Your Ref: Inet 000011371
Our Ref: BE/104/11/
Please ask for:
Miss K Rawlins

Erection of a detached single garage. Amendments to BE/51/08. (Re-submission following BE/57/11.)

Land Adj. 37 The Croft Bognor Regis

Proposed New Detached Single Garage
at
Land Adjacent to 37 The Croft, Bognor Regis
for
Mr R Lailey
Drawing PG03 July 2011 Scale 1:100
Proposed Plan, Roof Plan and Elevations

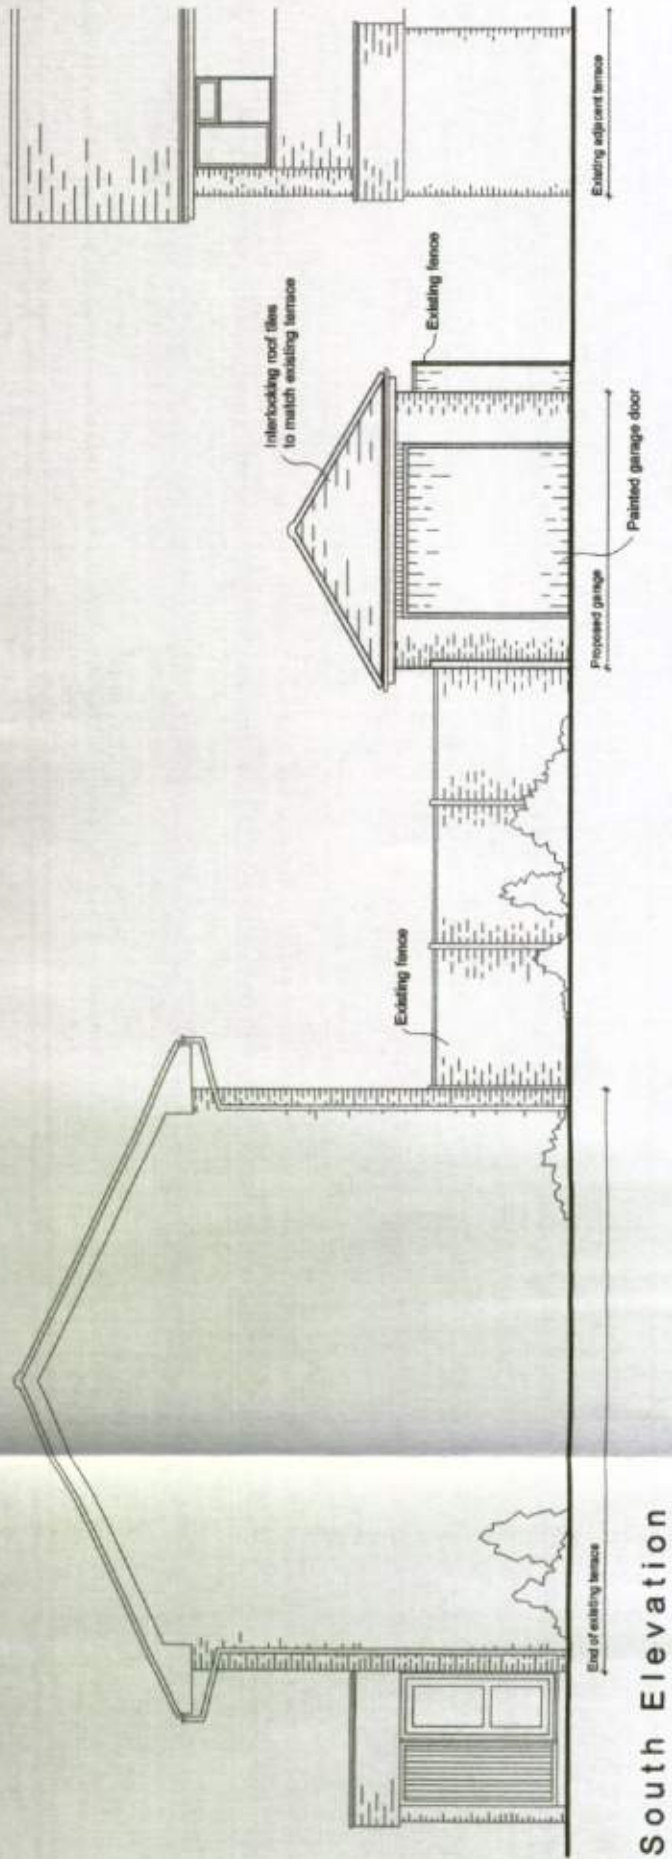
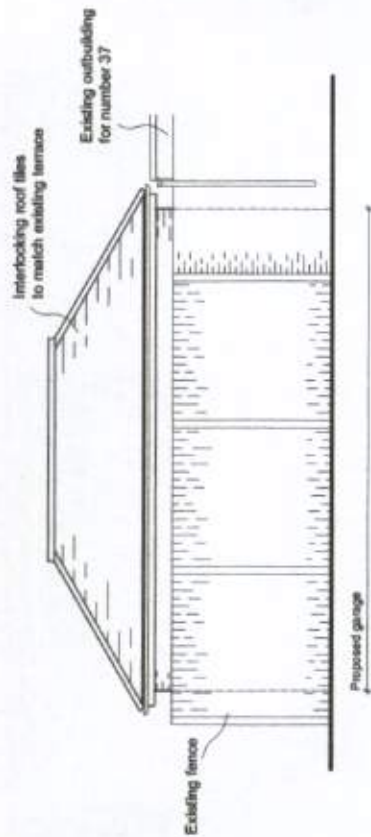
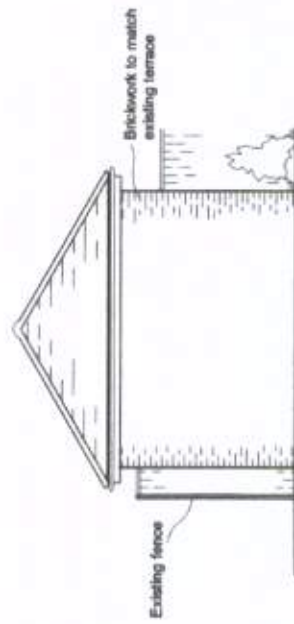
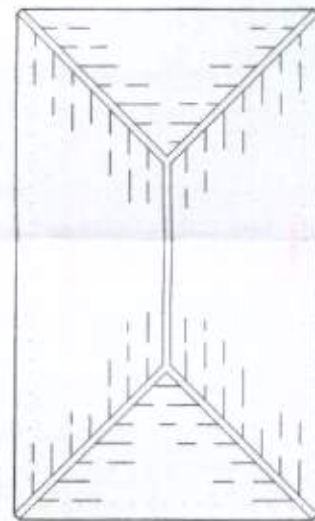
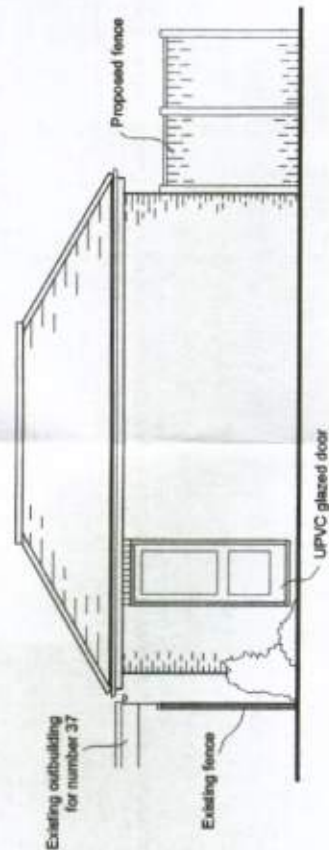
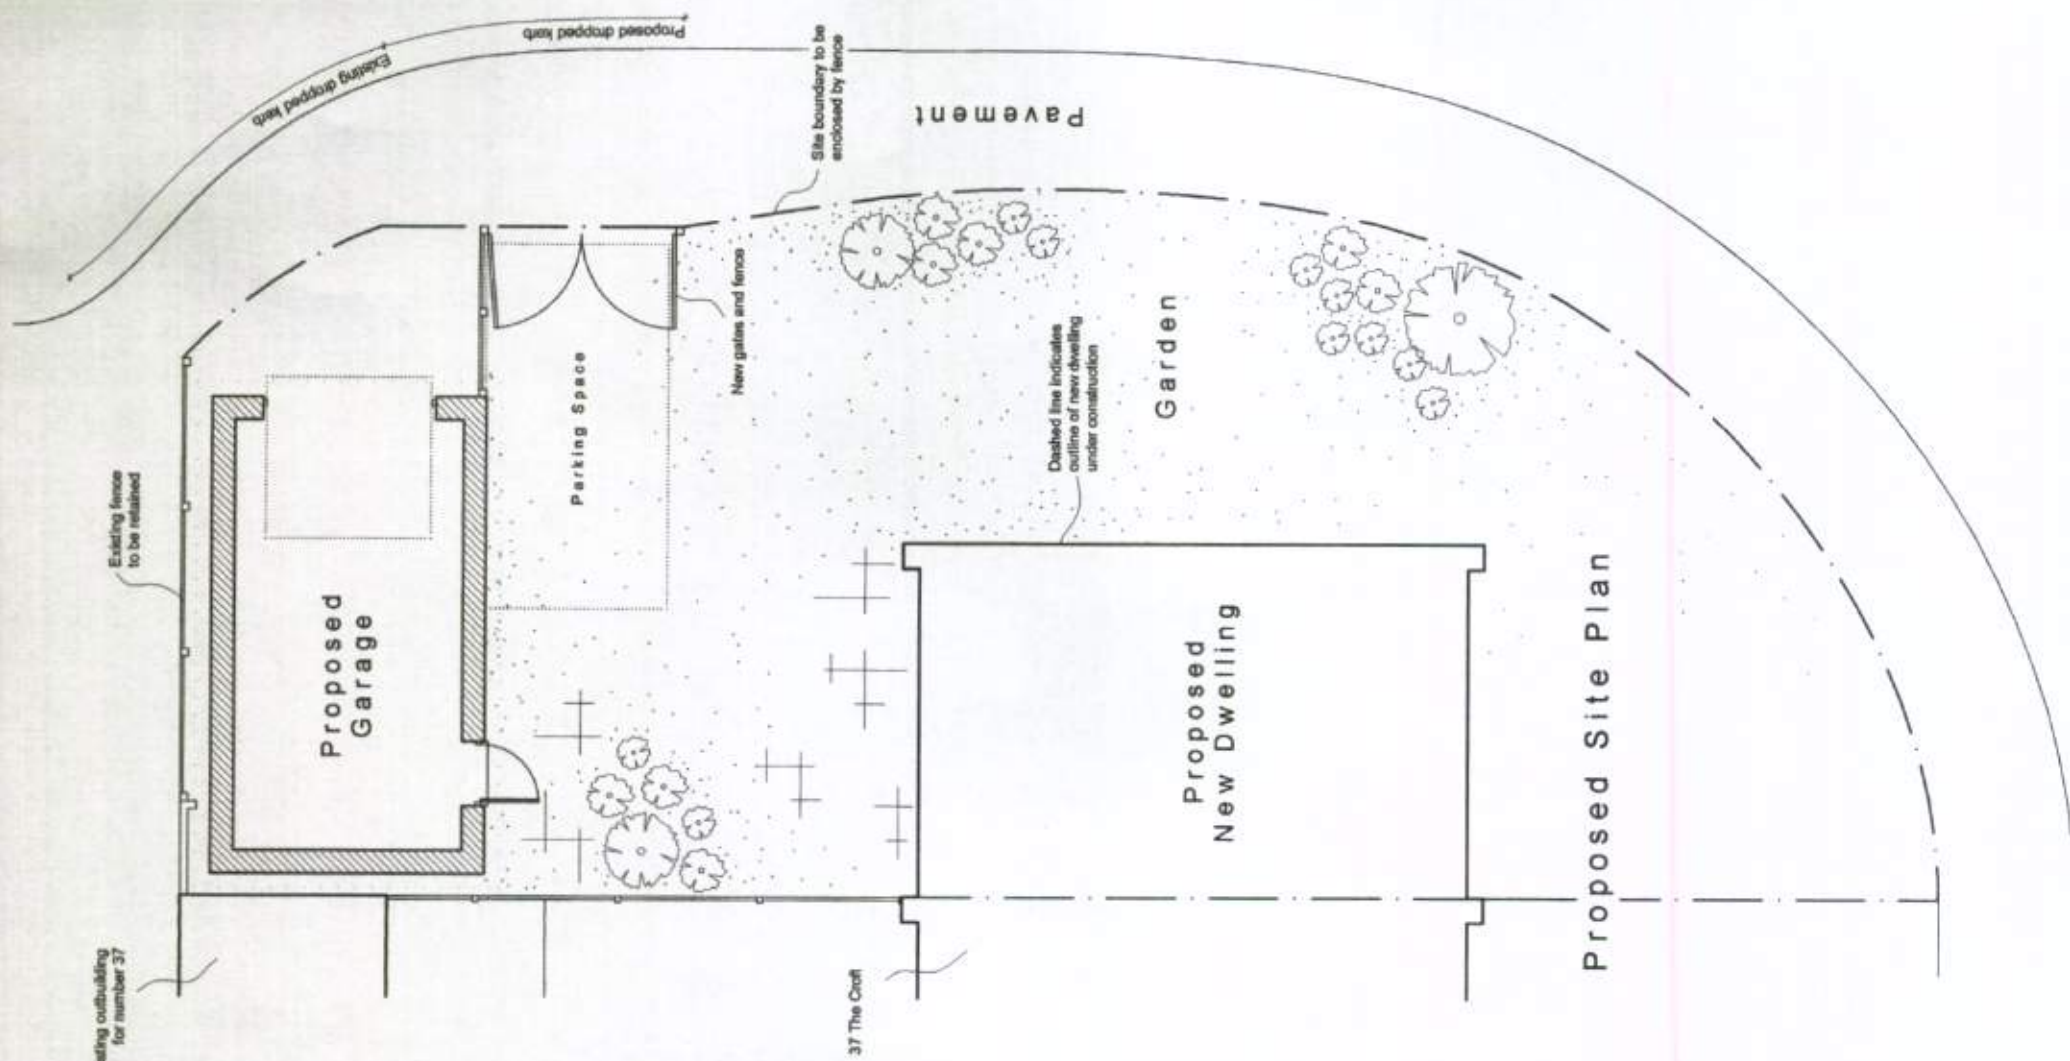
Apart from the over development of this site as previously commented on in your refusal of the previous application BE/57/11 and what I understood to be a comment at the Planning meeting in July, that the whole development (ie :- BE/51/08) would not now meet current criteria (PPS3?), I consider the design to be out of character with the surrounding area, by virtue of it's pitched and tiled roof.

Also the 'outbuilding' shown on the application plan (Drg PG03), is of the same construction (ie:- flat roofed) as the garages elsewhere on the estate and as far as I am aware has a garage up-and-over door, which cannot now be accessed. It is also noted that the design does not show any dimensions. **Should these not be specified, so that the proposal can be constructed to the correct dimensions.**

I wish to object to the proposal for a detached single garage to be erected on the land adjacent to 37, The Croft. There is a garage/out building labelled on the plans behind the proposed new garage that has garage doors on it and could not be accessed if a new garage was built next to it as it would block the doors to it.

The new garage seems
unlike a garage as most are flat
roofed + more to be modelled on
an extension as elsewhere on the
estate for annexes.
